CITY OF ALBUQUERQUE

March 2, 2016

**RE: Independence Square
Grading and Drainage Plan
Engineer's Stamp Date 2-15-16 (File: E17D076)**

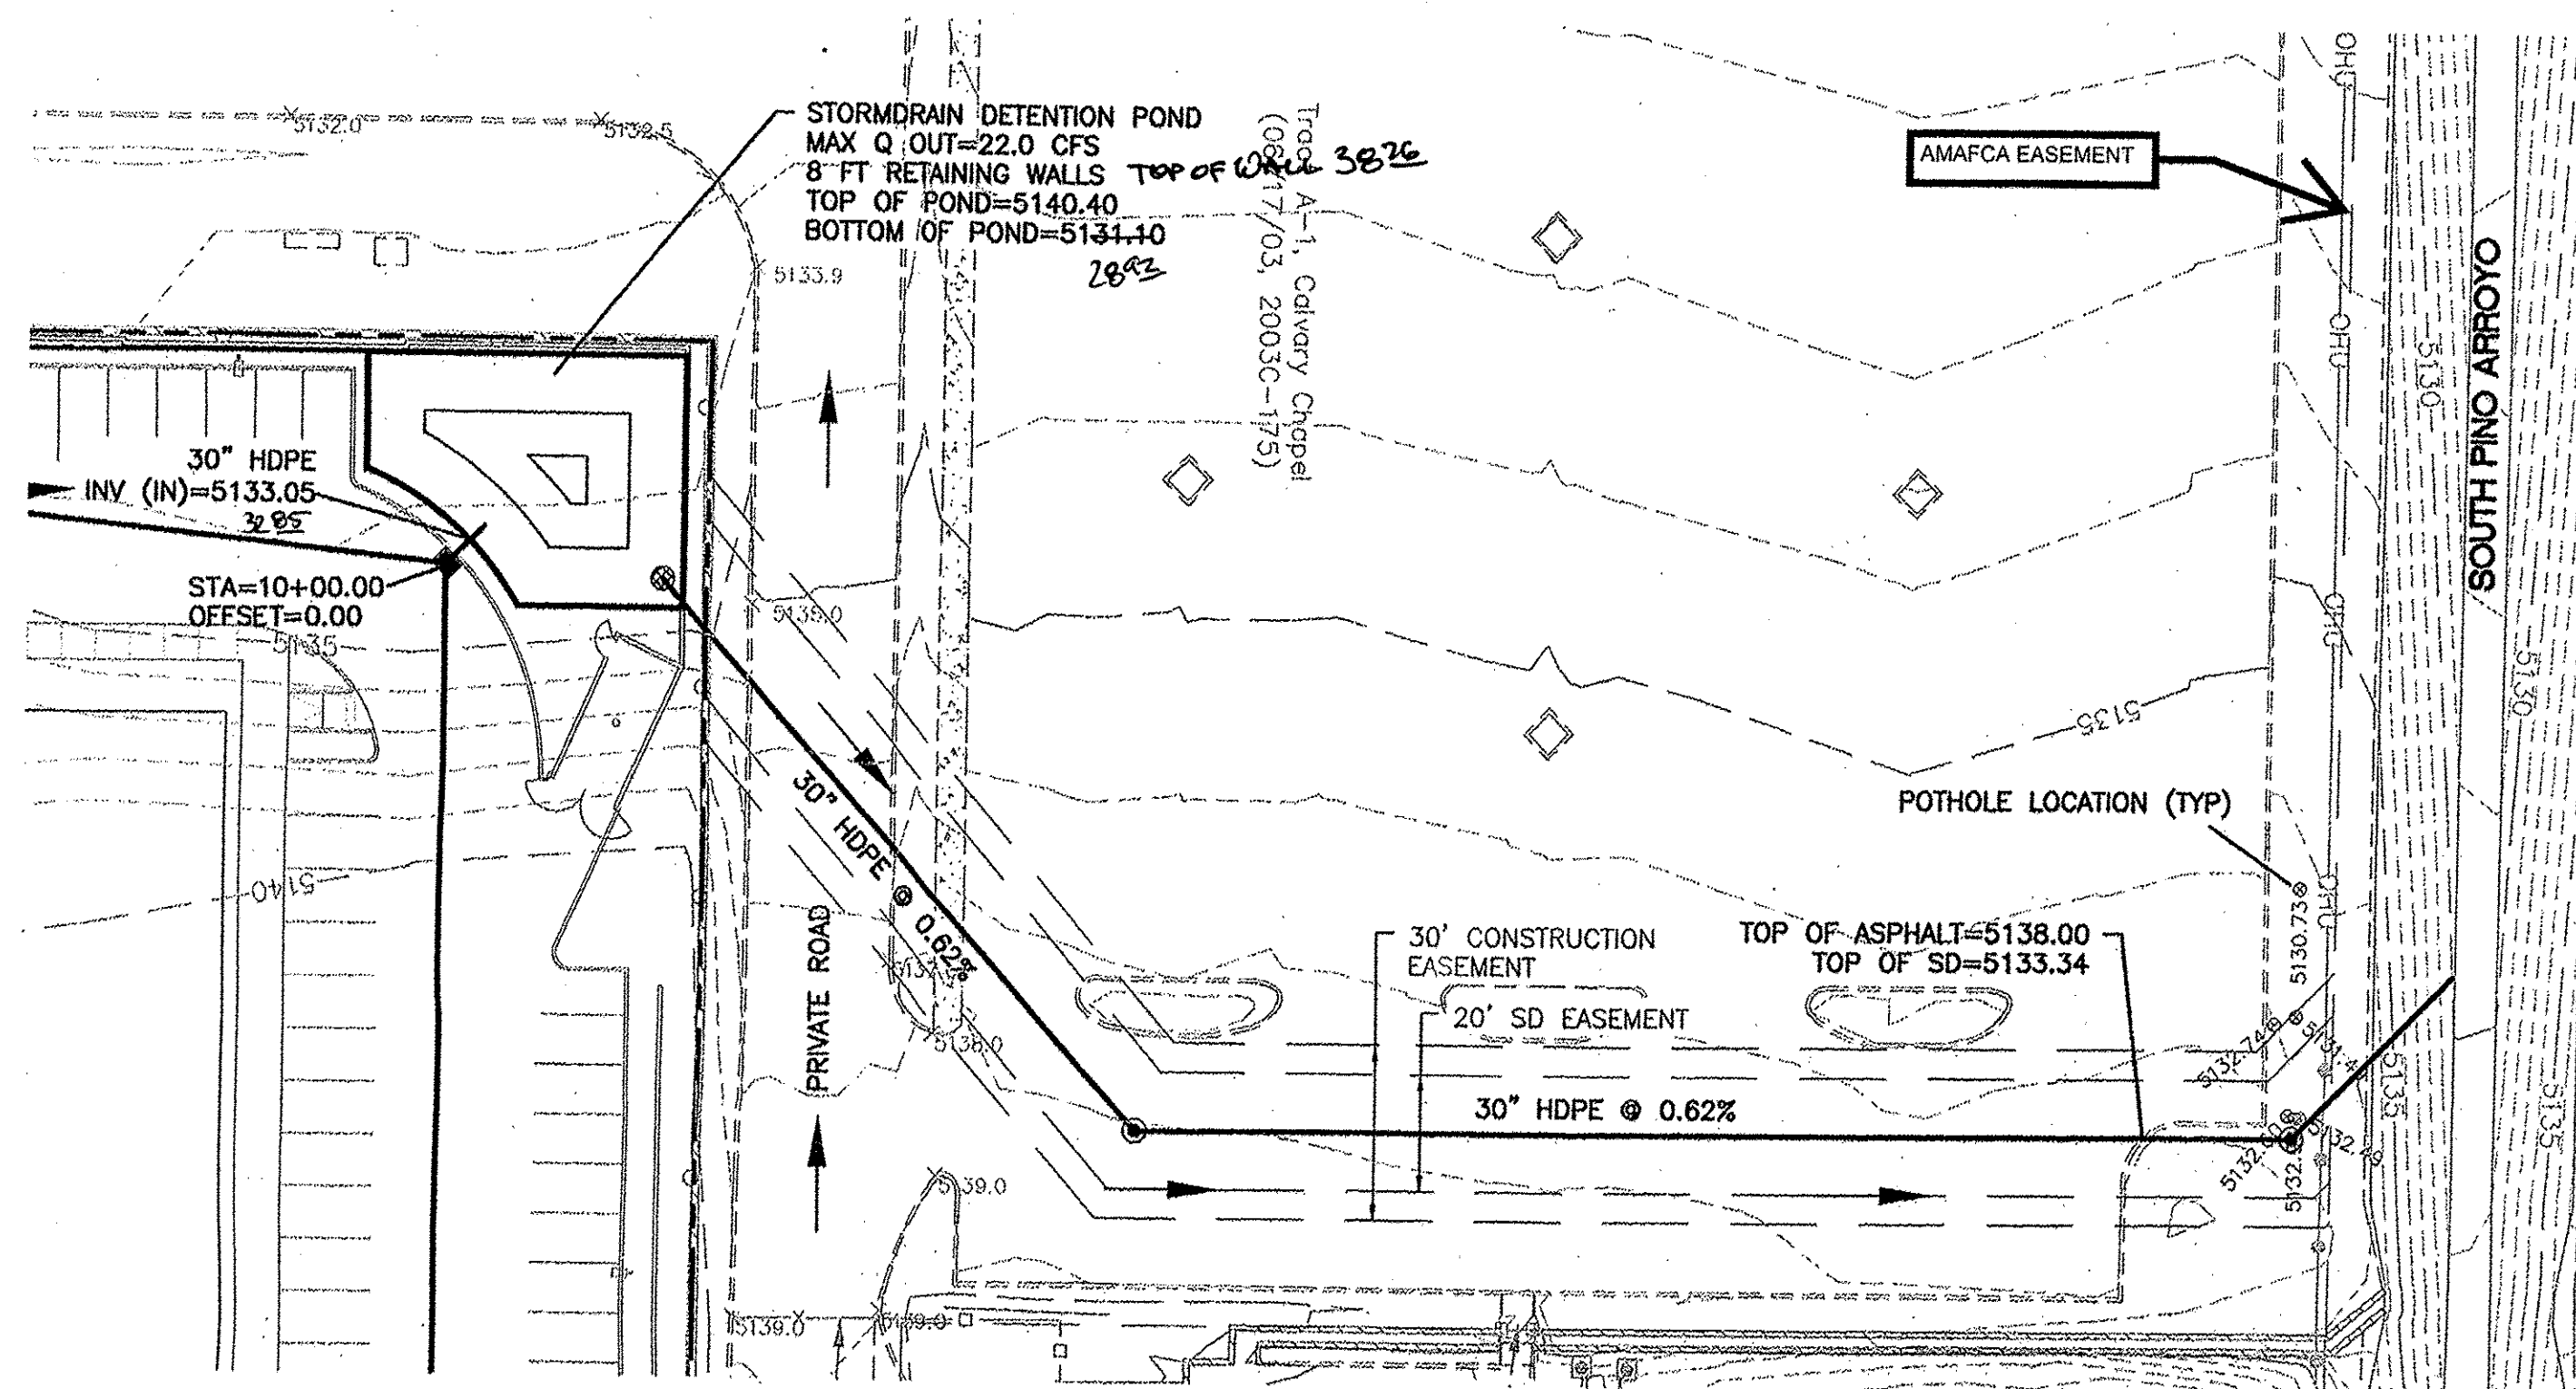
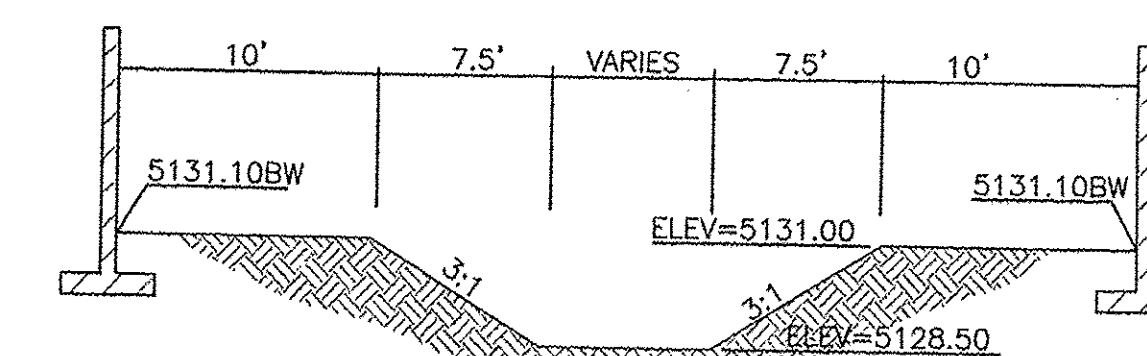
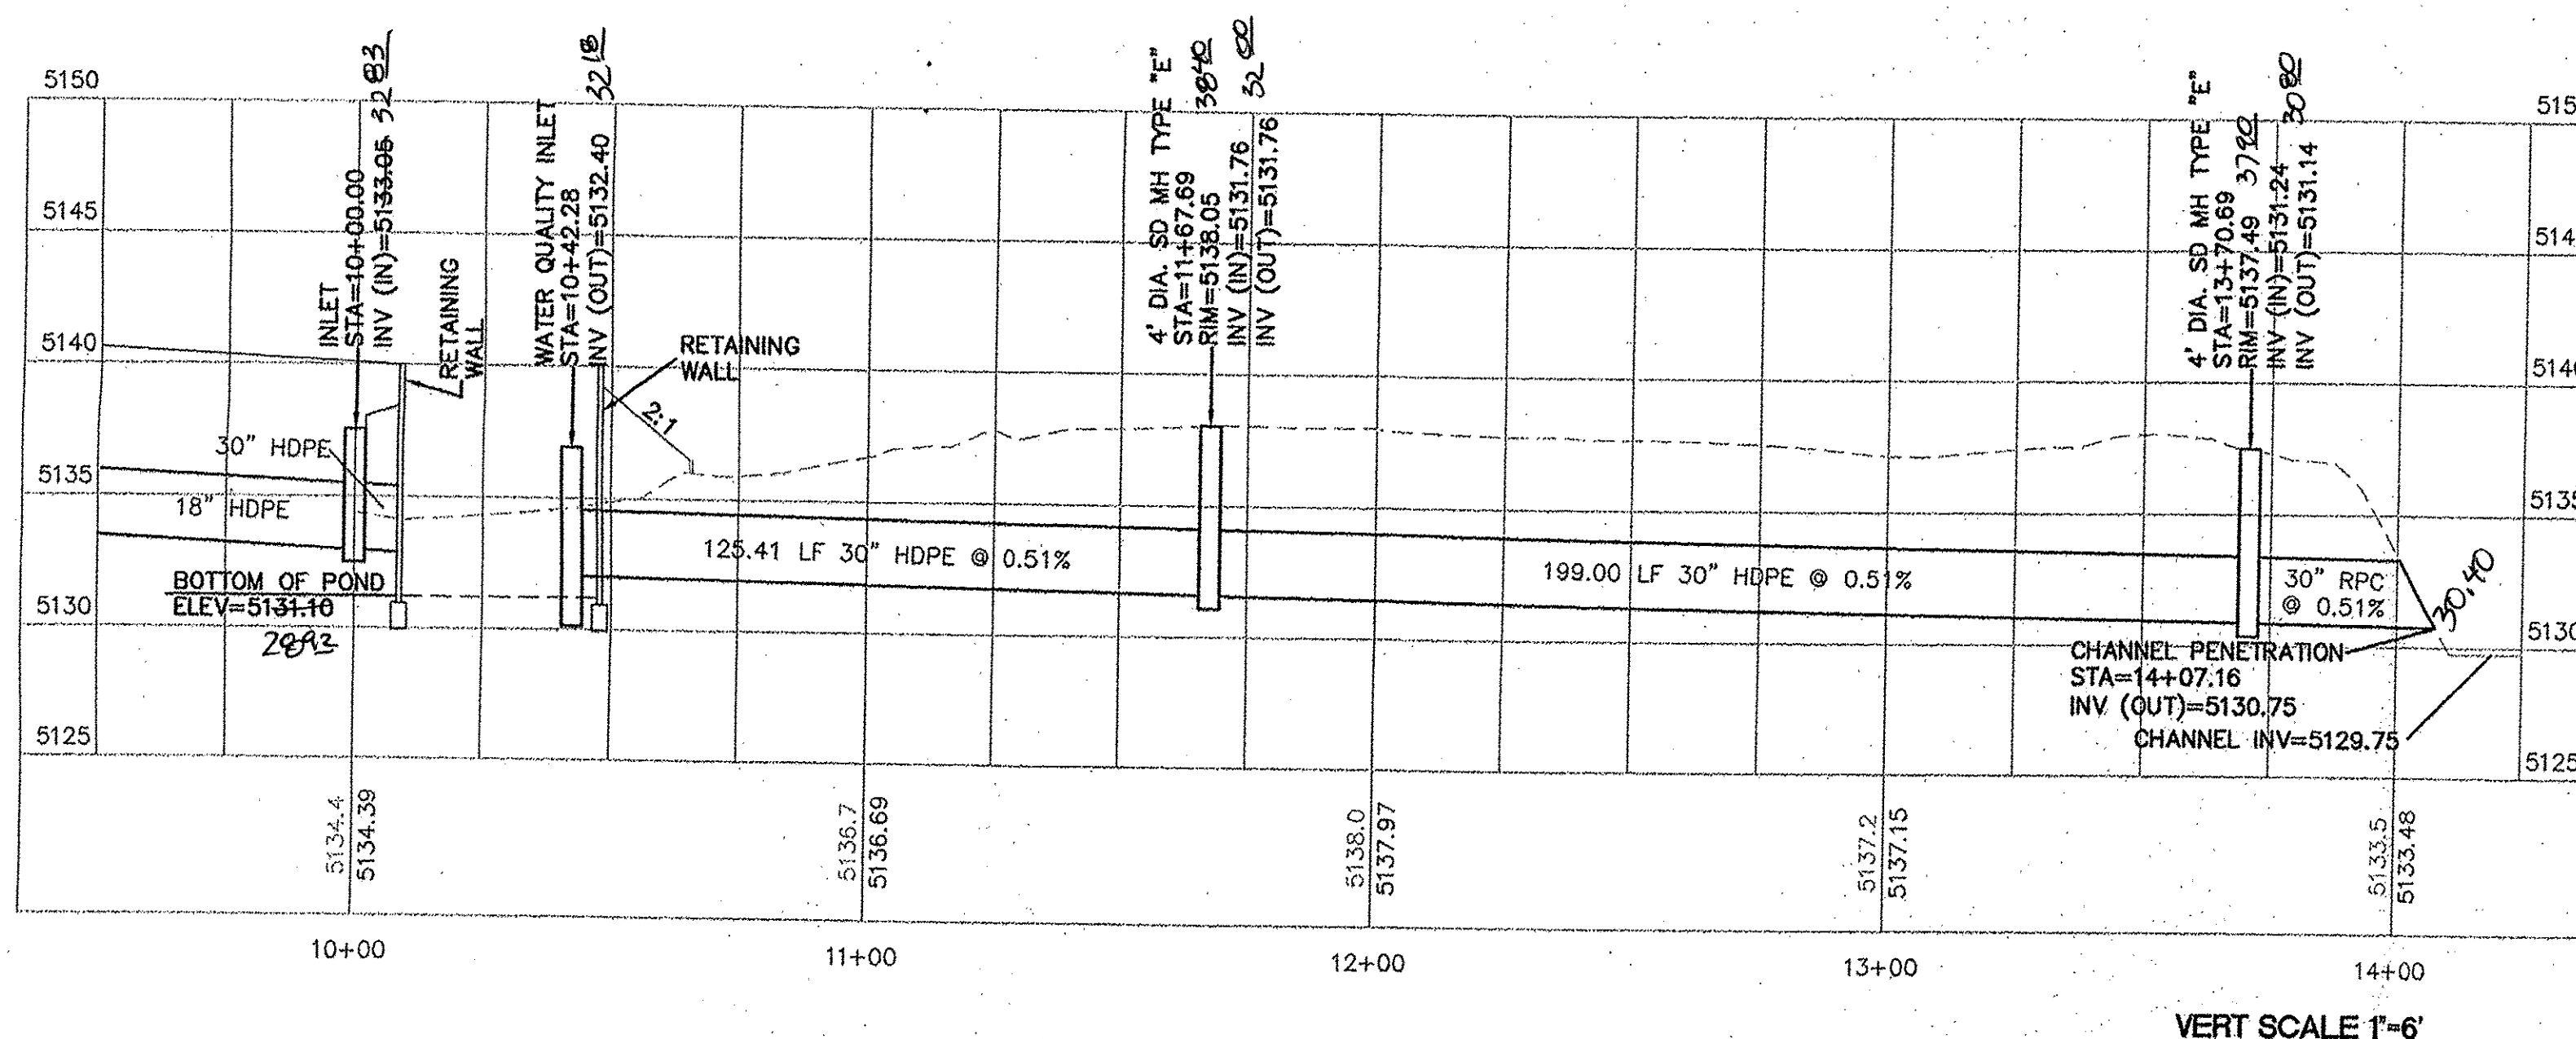
1. The first flush exhibit needs to be clarified to correspond with the calculation worksheet. The sum of the ponding capacities should be checked.
2. The outlet into the detention pond is not shown or detailed in the storm drain plan or profile.
3. An ESC Plan is approved by the City's Storm Water Quality Engineer for the purpose of full Grading.
4. The license agreement with AMAFCA needs to be approved by their Board.
 - a. All details required by AMAFCA regarding the opening into the channel need to be shown on the Grading Plan.
